City of Portland, Maine - Building or Use Permit Application

Permit No: 03-0137	Issue Date: APR 10 2003	CBL: 183 B025001 <i>226</i>
-----------------------	-----------------------------------	--------------------------------

Past Use: Vacant	Proposed Use: New Single Family / Build 26' x 38' Cape Style Home with 22' x 24' attached 2 car garage.	Permit Fee: \$933.00	Cost of Work: \$130,000.00	CEO District: 3
---------------------	--	-------------------------	-------------------------------	--------------------

After reviewing the application for permit for the above property, the following issues need to be addressed in order to proceed with the approval process:

Foundation Plan

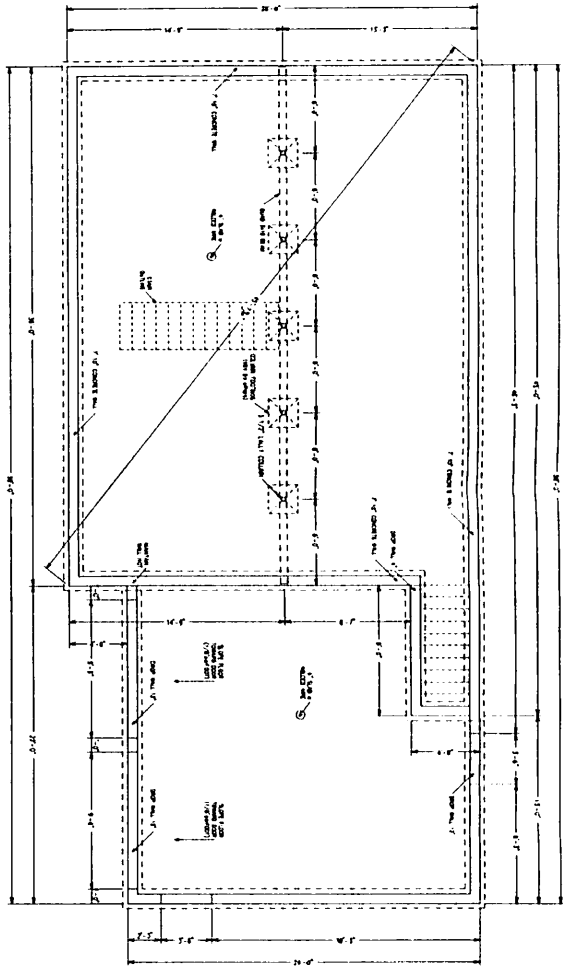
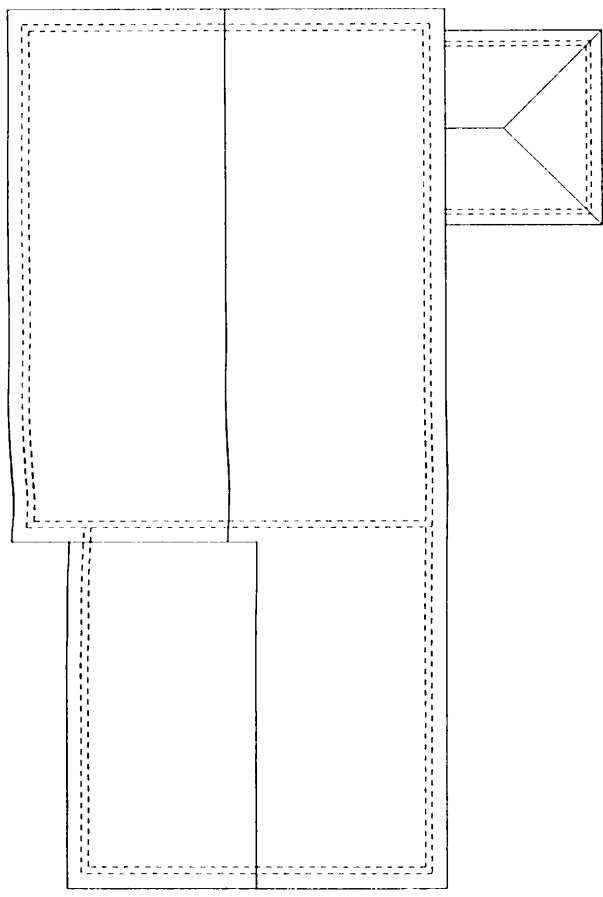
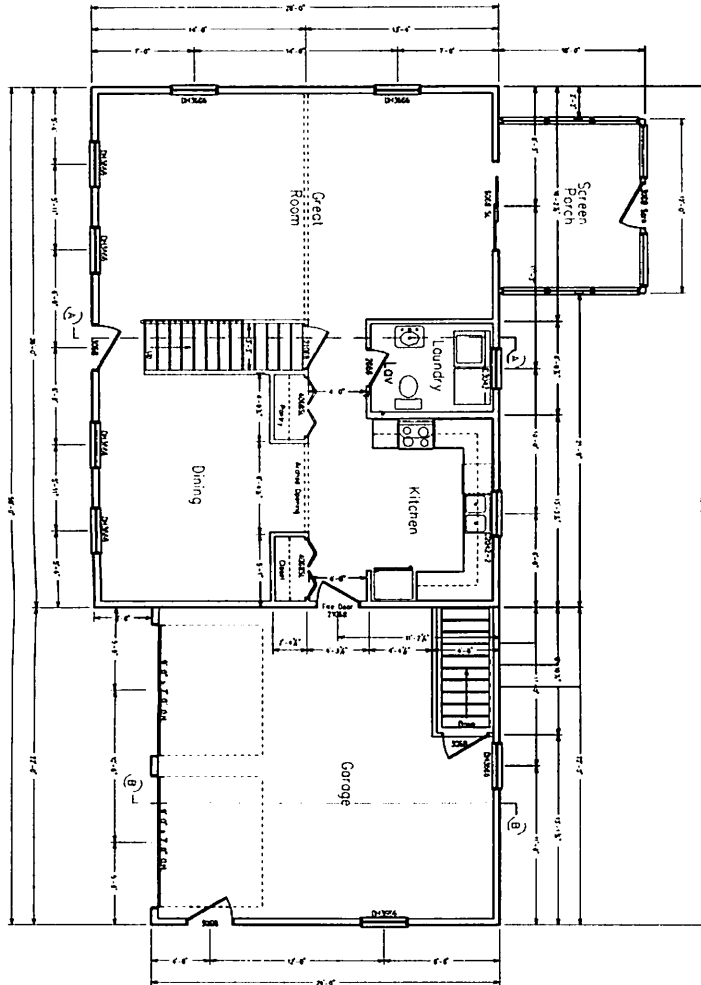
1. Soil type/presumptive load value
2. Foundation drainage filter (Portland requires fabric or membrane)
3. Basement/foundation ventilation
4. Attic joist & collar tie dimensions
5. Floor sheathing material
6. Fastener schedule/table
7. Fire rating of garage and door ratings (2 options based on use of space above)
8. Full construction plans for the screen porch including footings/foundation
9. Handrail detail if it is not part of the guardrail (must have returned ends)

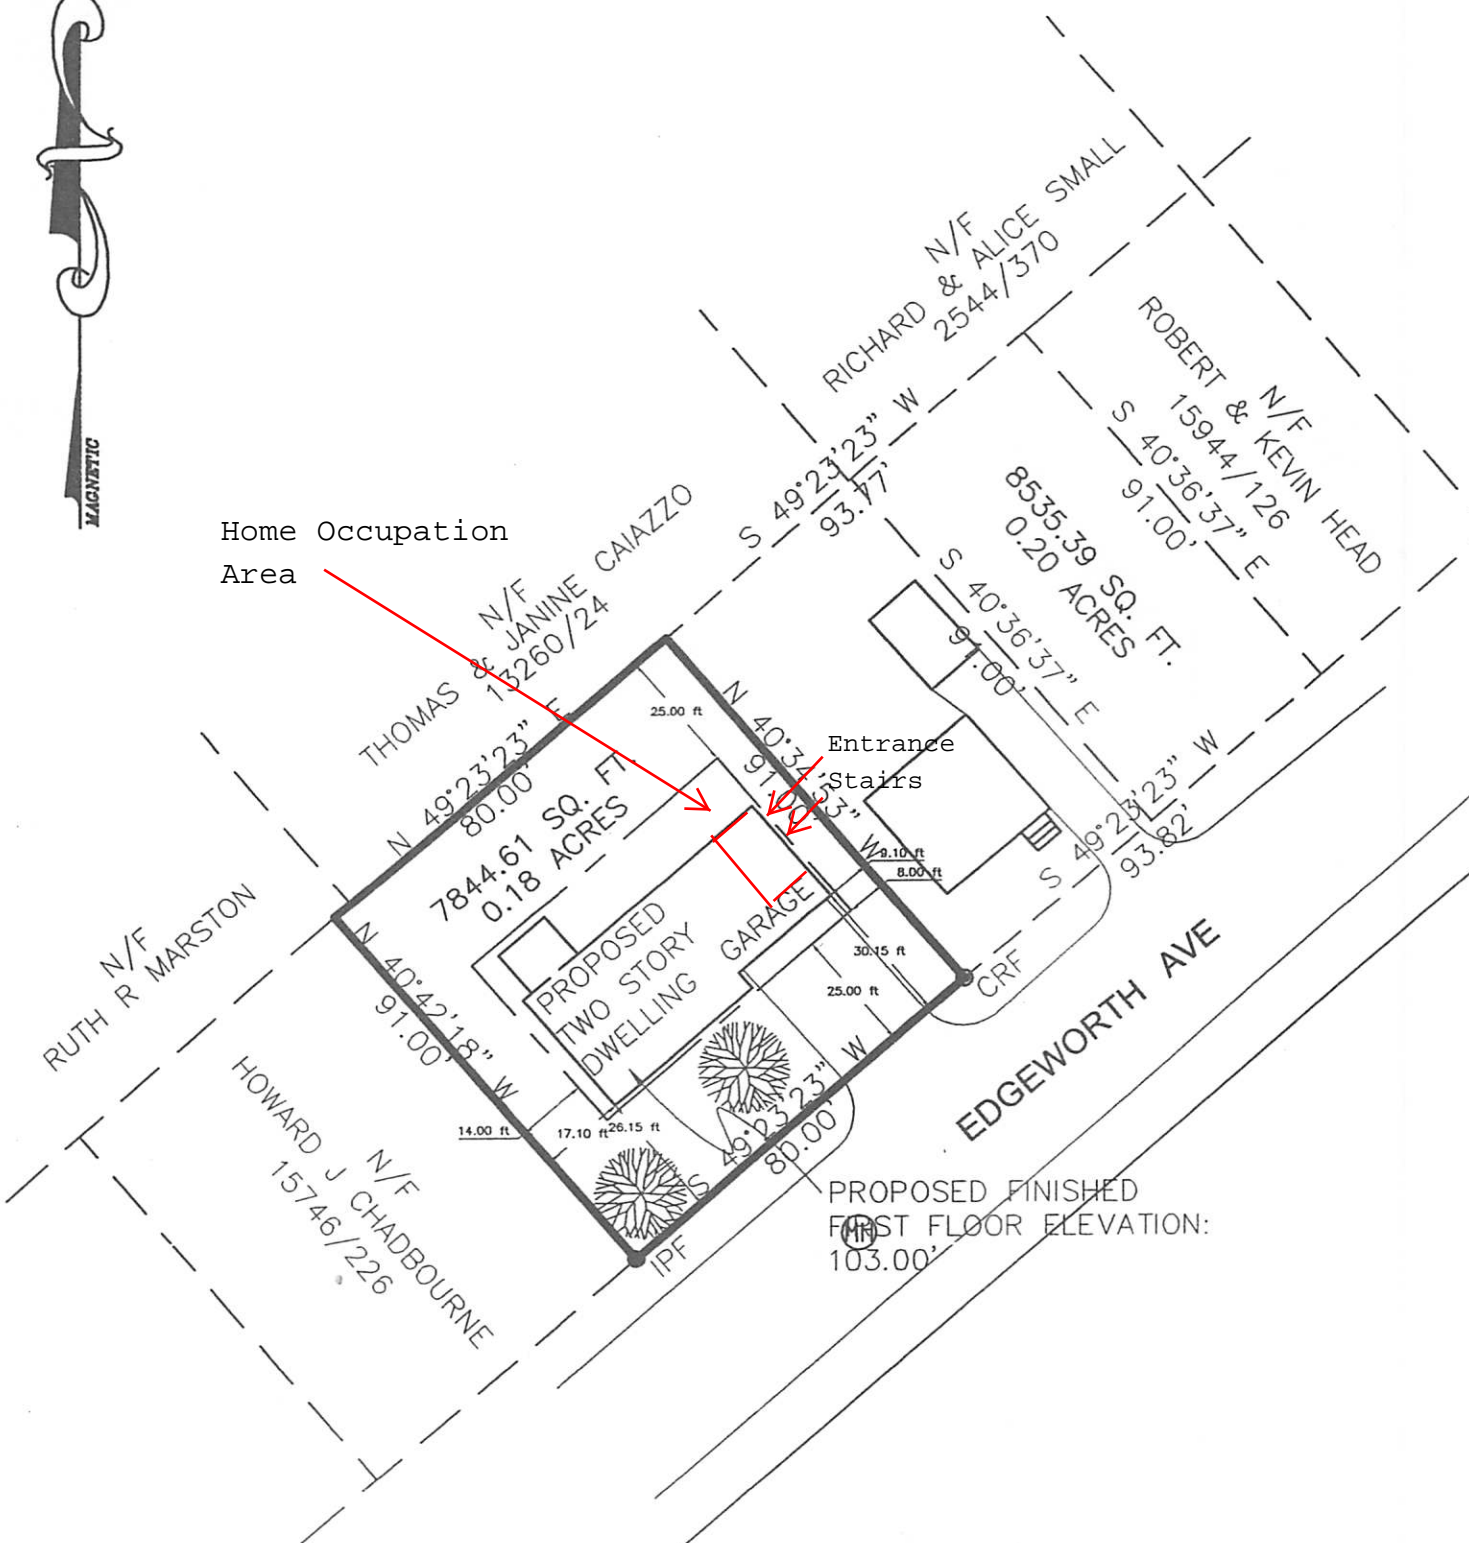
Rear Yard - 25' req - ~~25'~~ scaled to deck revised to 25'

Needs to show front porch stairs
see plans 3/20/03 added

Jay,
Have you had a chance to look at this yet? Everything is ok except for the fact that they are not showing a front stoop and stairs and the drop off is pretty significant. I have requested Paul French to revise his site plan.
Marge

3/26/03
received revised
plans
